2nd March 2019

RE: Planning Application **2019/90269**

We are writing to you to object to the above planning proposal.

Stocks Bank Rd (20)001 /
Proposed GA

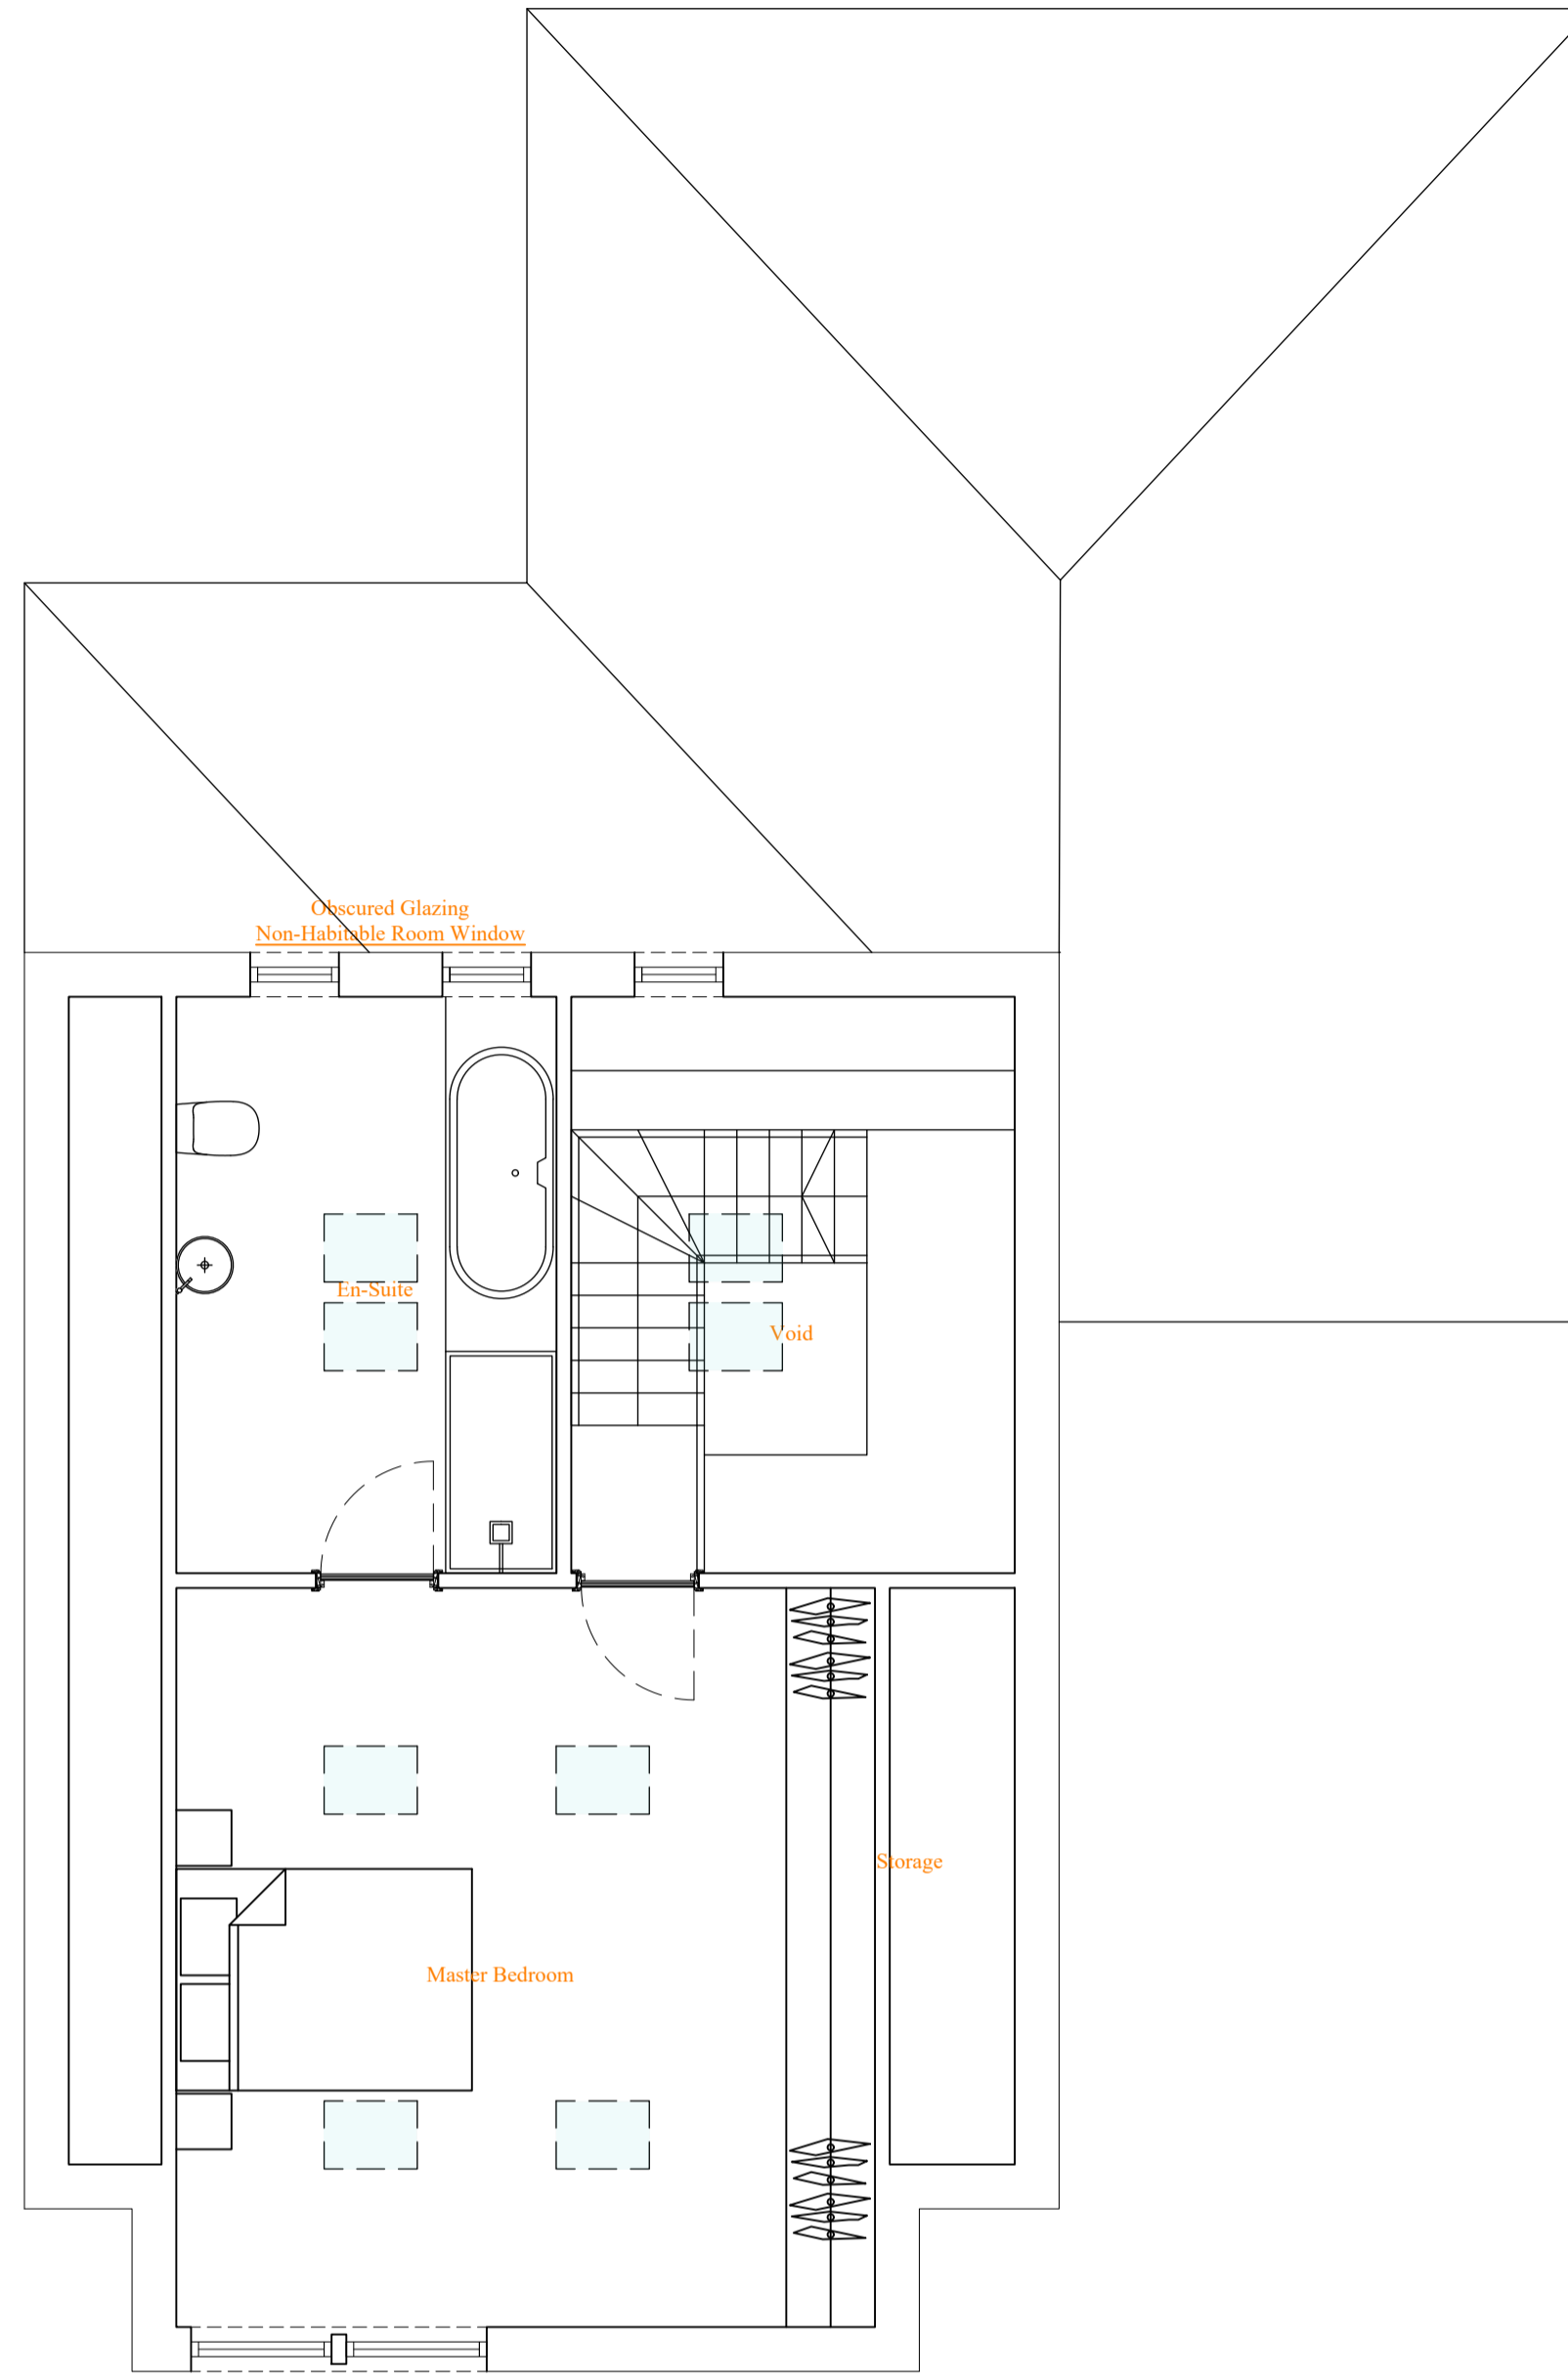
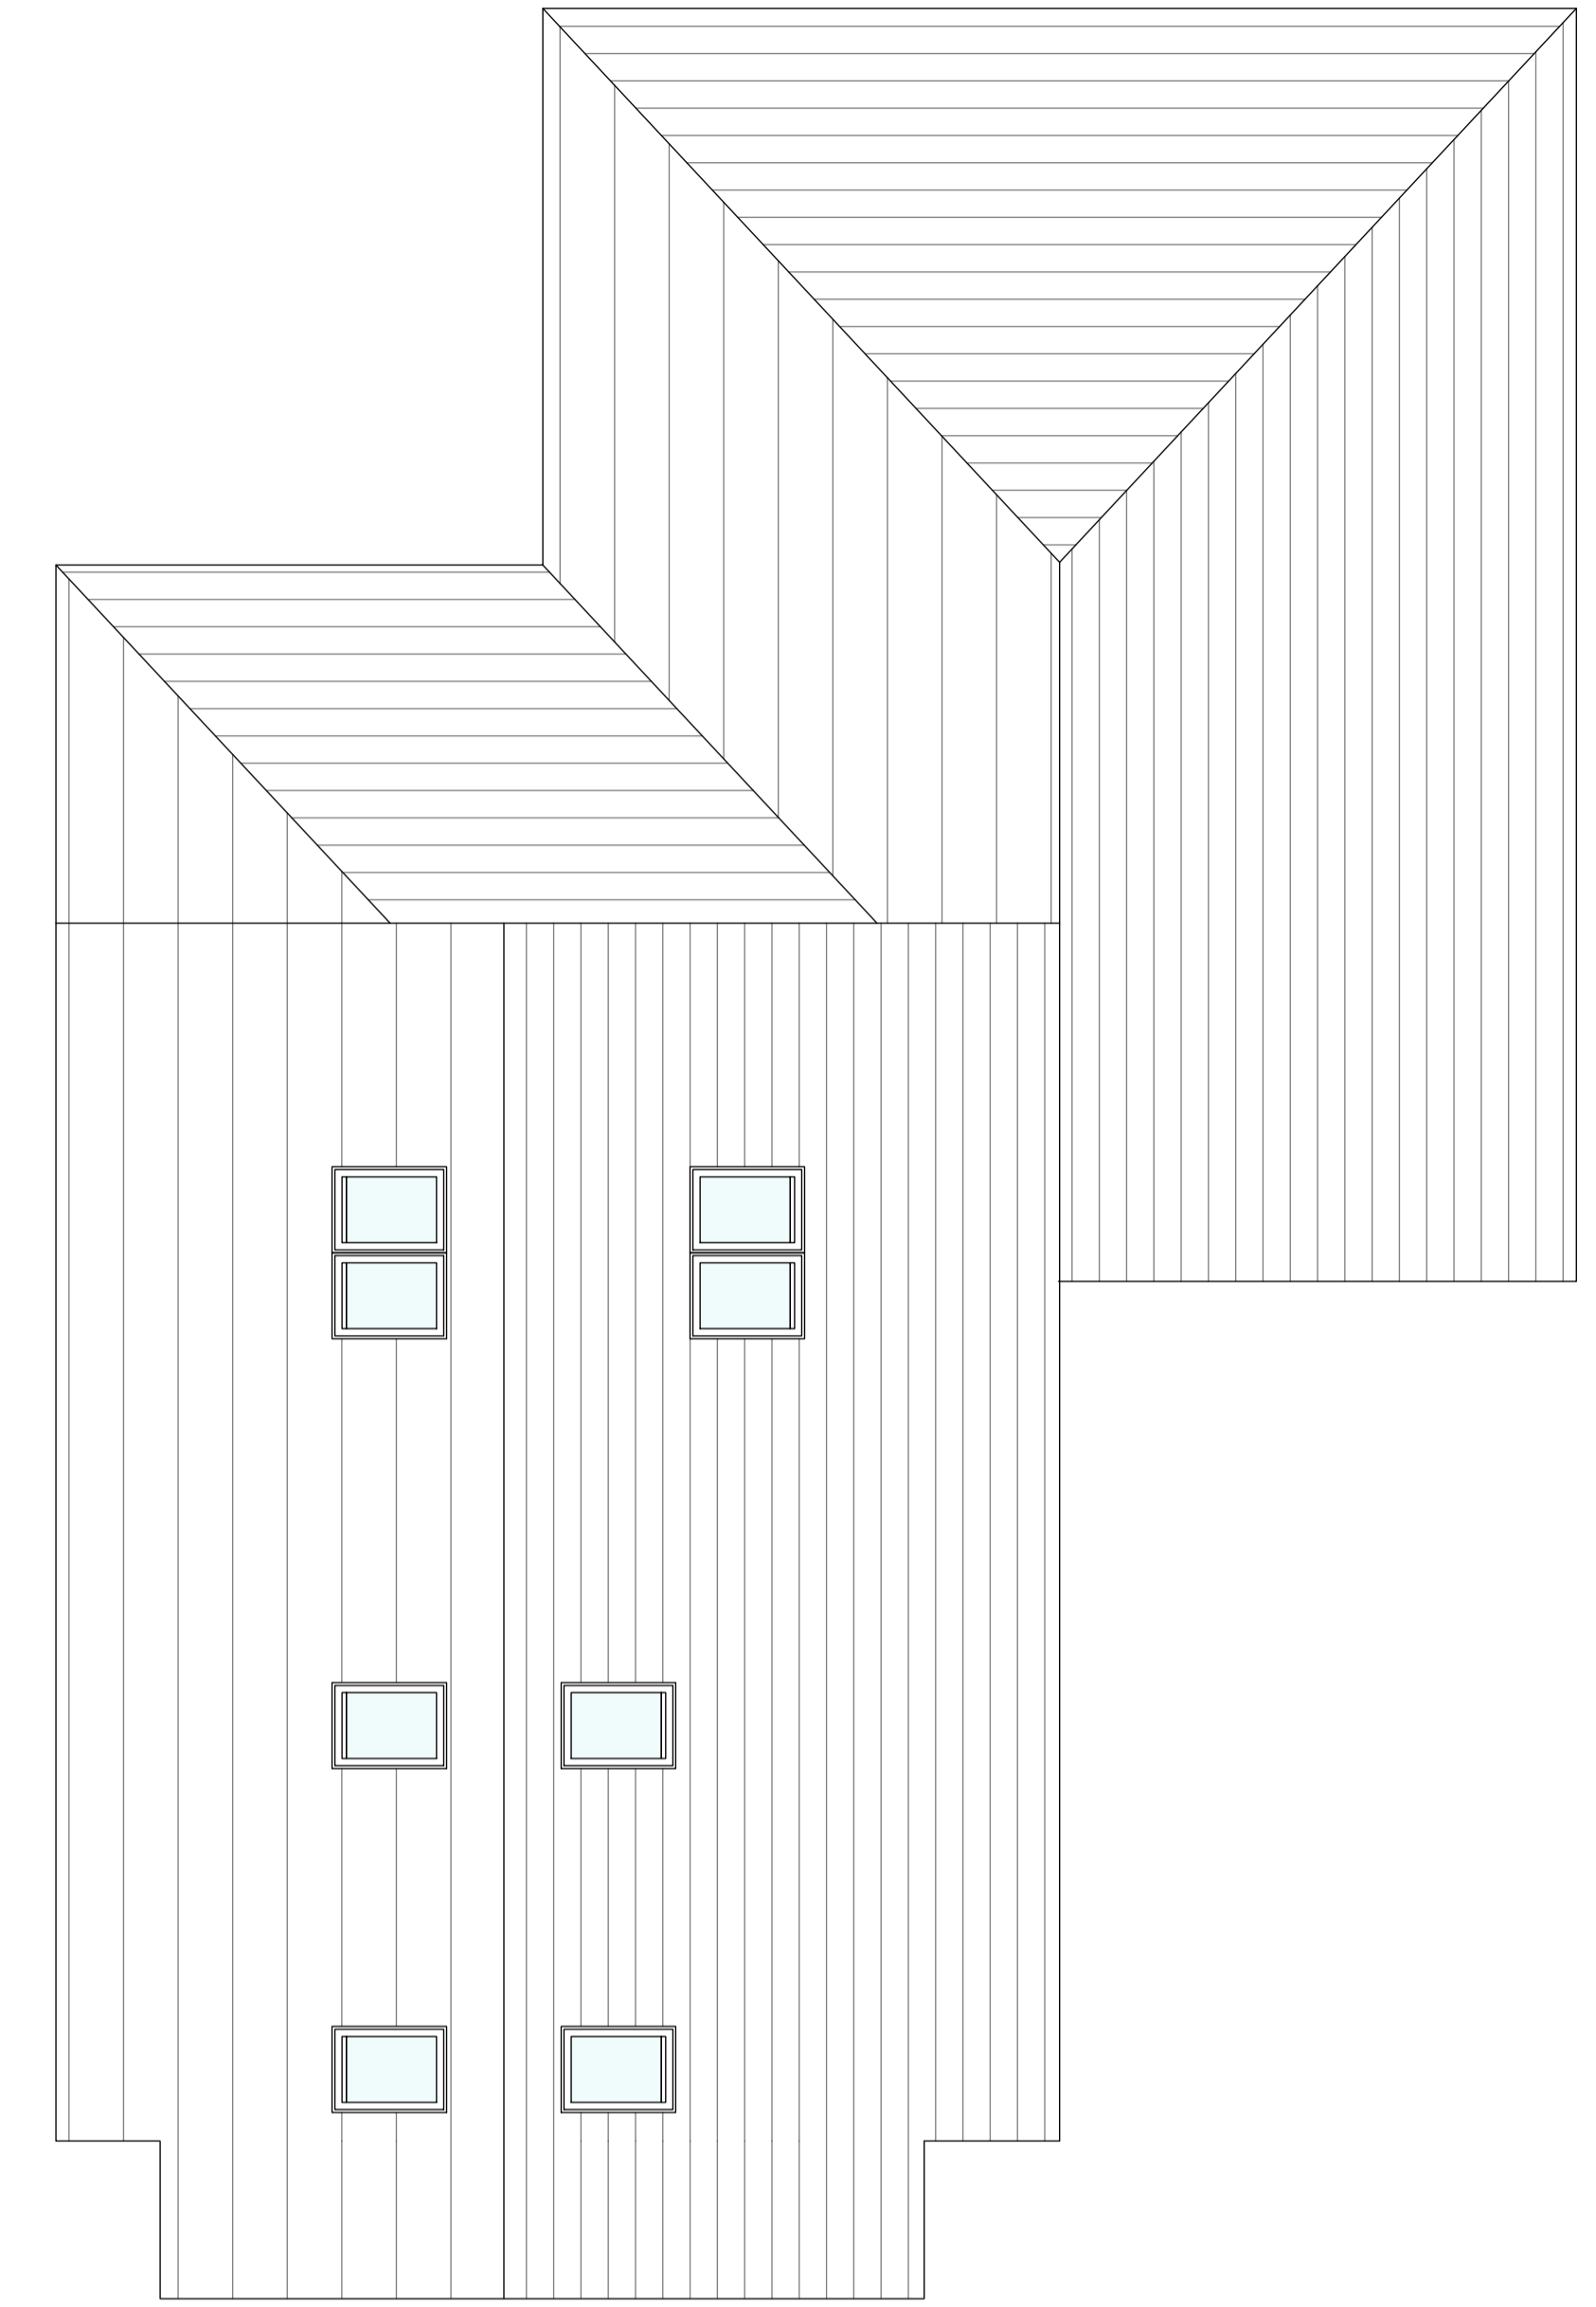
The plan is to demolish the garage and replace with a large house deemed a bungalow on the planning application when in fact it is a one and half storey house with a large footprint.

The planned property is to [redacted] which is claimed as non-habitable in the planning application yet was viewed as habitable by the Appeal Officer in the previous refused application, will be looking out on a brick wall and the entrance door of the [redacted]. Despite being set back the proposed property's entrance will be 9 metres away and the brick wall less than 6 metres away. There are three roof windows in the property [redacted].

The footprint of the proposed property is even larger than the previously rejected application and it is classed as a bungalow however it still retains a second floor. The previous application was rejected due to the proximity of the [redacted].

The actual footprint of the proposed development is almost a quarter larger than the previous application and is still being fit into the same plot.

There is reference to the existing garage structure not being overbearing, which would be the case if the proportions of the garage were not be extended as they will be in the plan and as such the front wall of the garage will be moved in front of our kitchen window and the roof height will almost double. The 'modest pitched' roof will be the primary outlook from the kitchen window.

The documents referring to the elevation are also incorrect as instead of two windows in the existing garage elevation, there will be three windows in the main block of the house including bedroom windows
